CITY OF ALBUQUERQUE

March 13, 2026

RE: 1416 Espejo St NE
Grading and Drainage Plan
Engineer's Stamp Date: 03/09/2026
Hydrology File: J20D043
Case # HYDR-2026-00089

Grading Plan

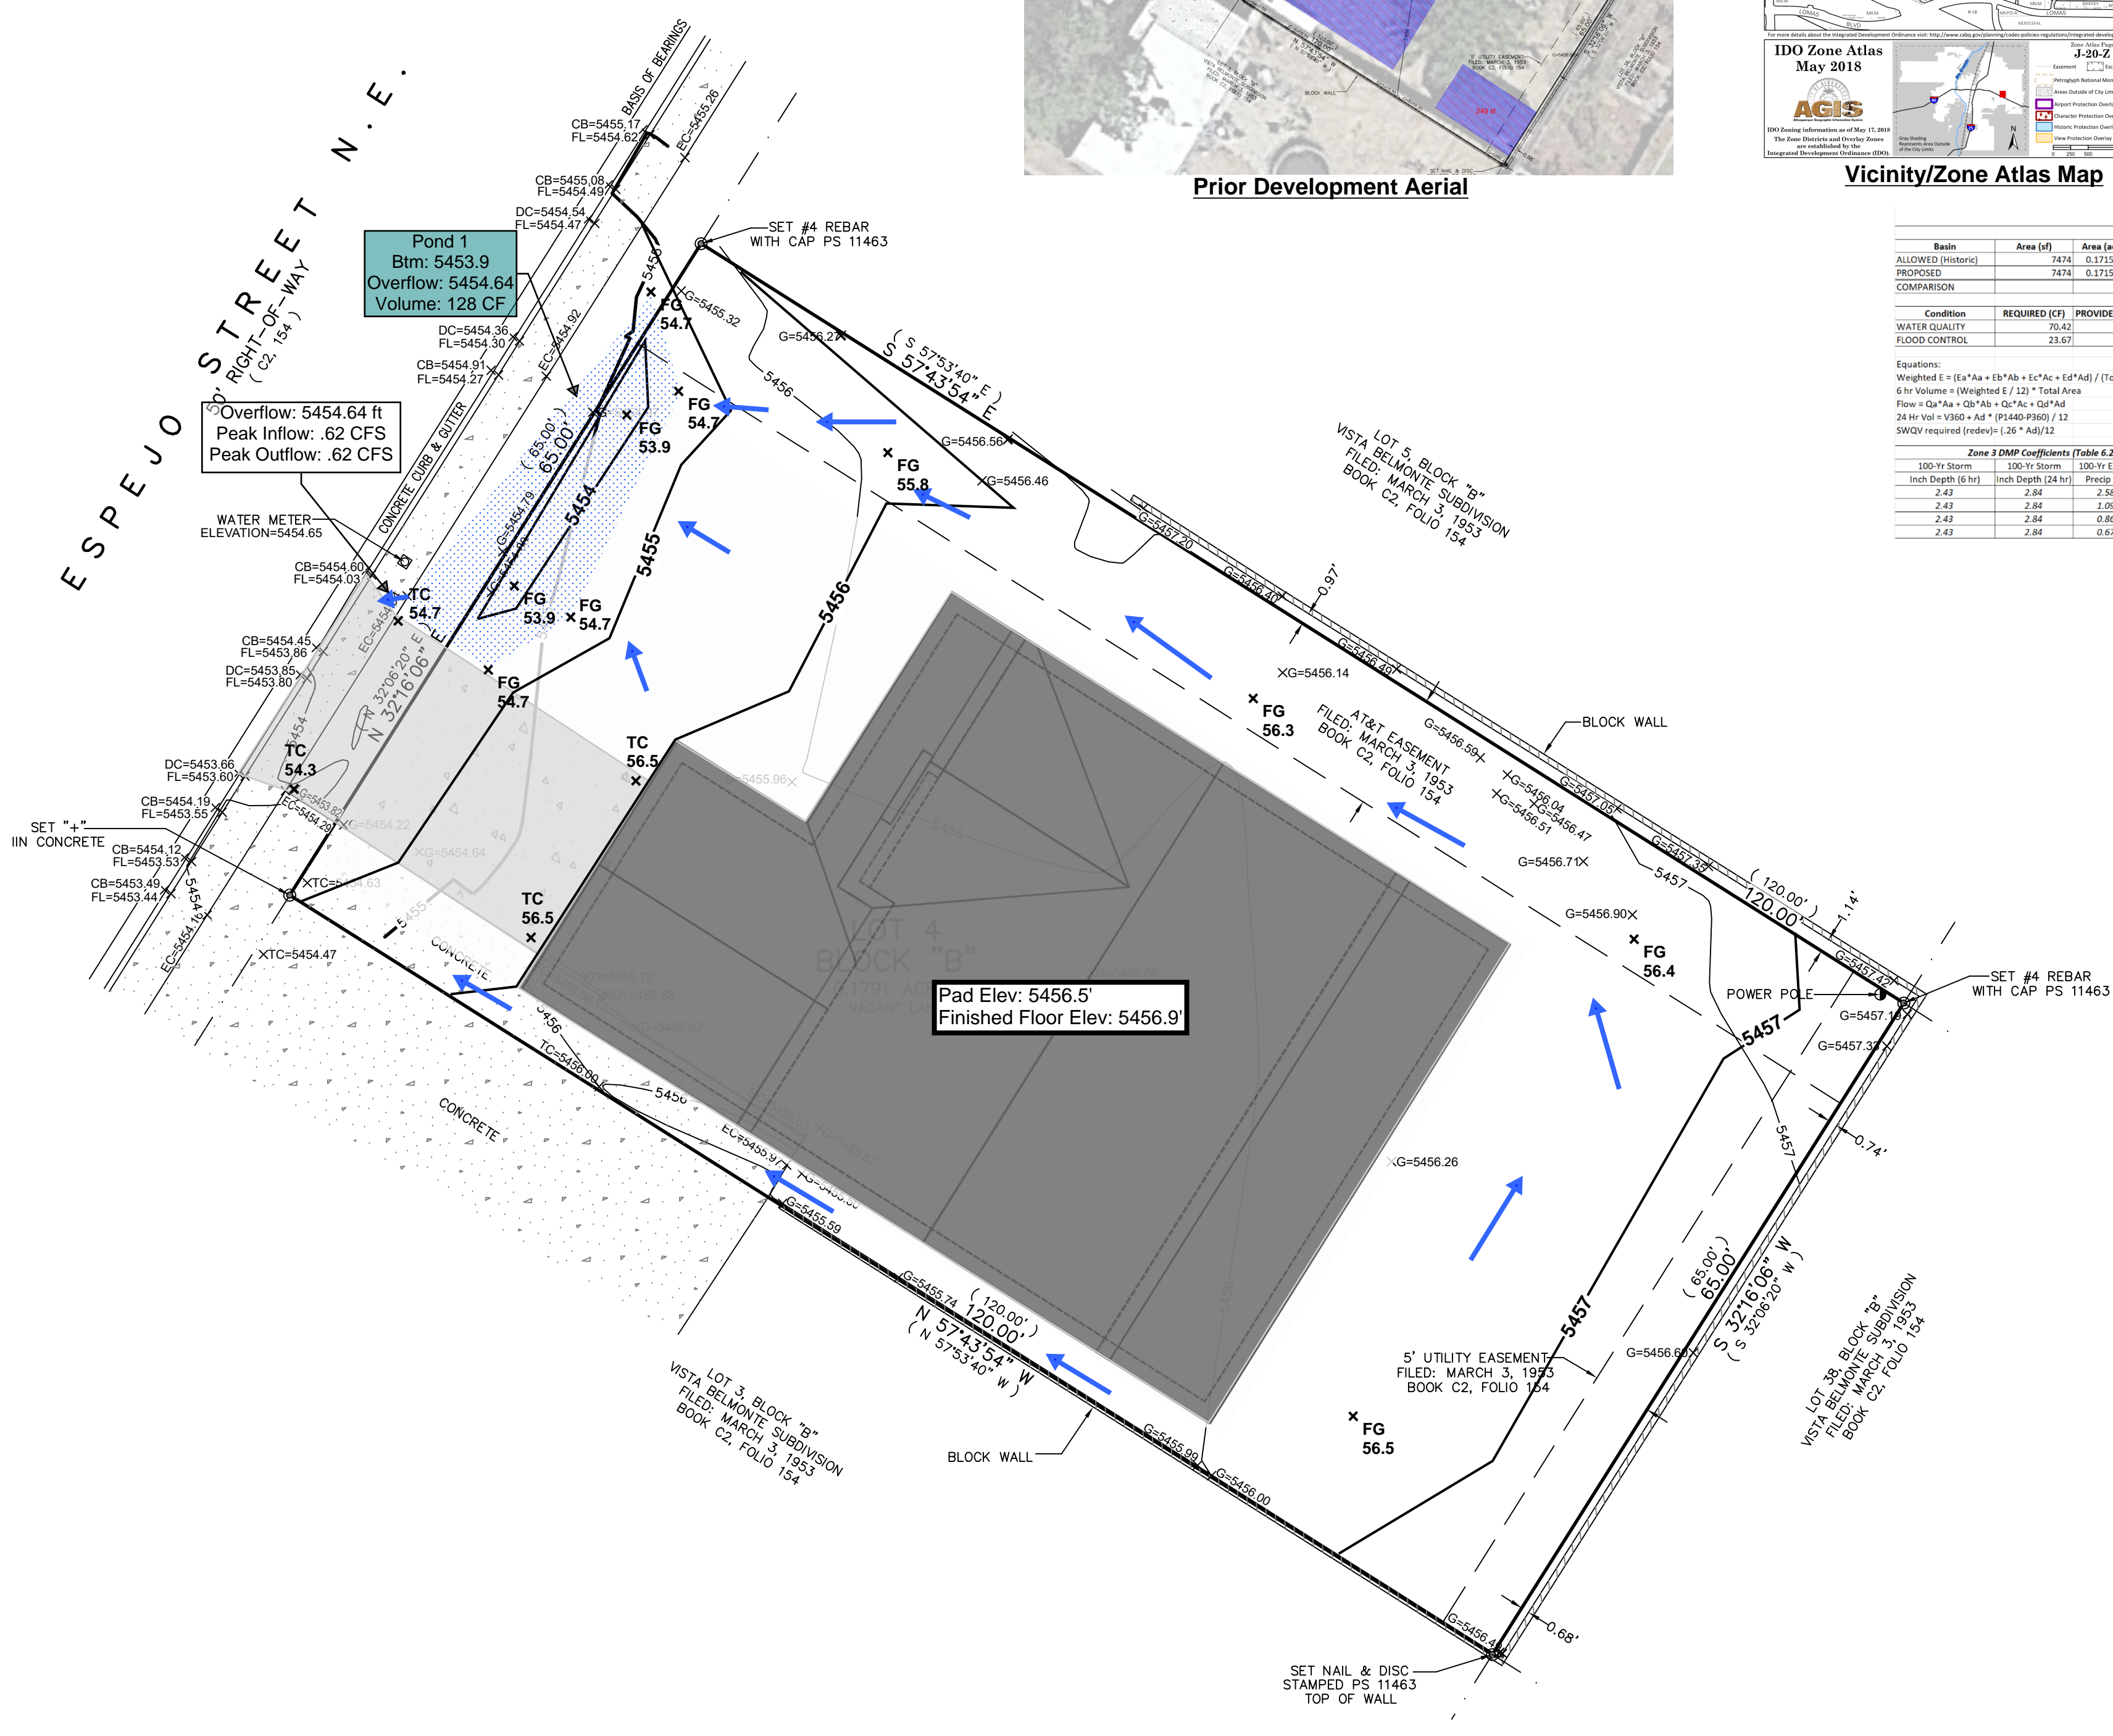
1. Please number the ponds and include a label on each with the SWQV and elevation, the 100-year volume and elevation, the peak 100 year inflow and outflow, the spillway crest elevation, the spillway flow depth, and the dam top elevation.

2. Please show calculations of both existing and proposed conditions. See calculation example below:

3. Remove Note #3. A Pad Certification is not required for this site.
4. Change DTIS to Building Permit as the approval being sought.
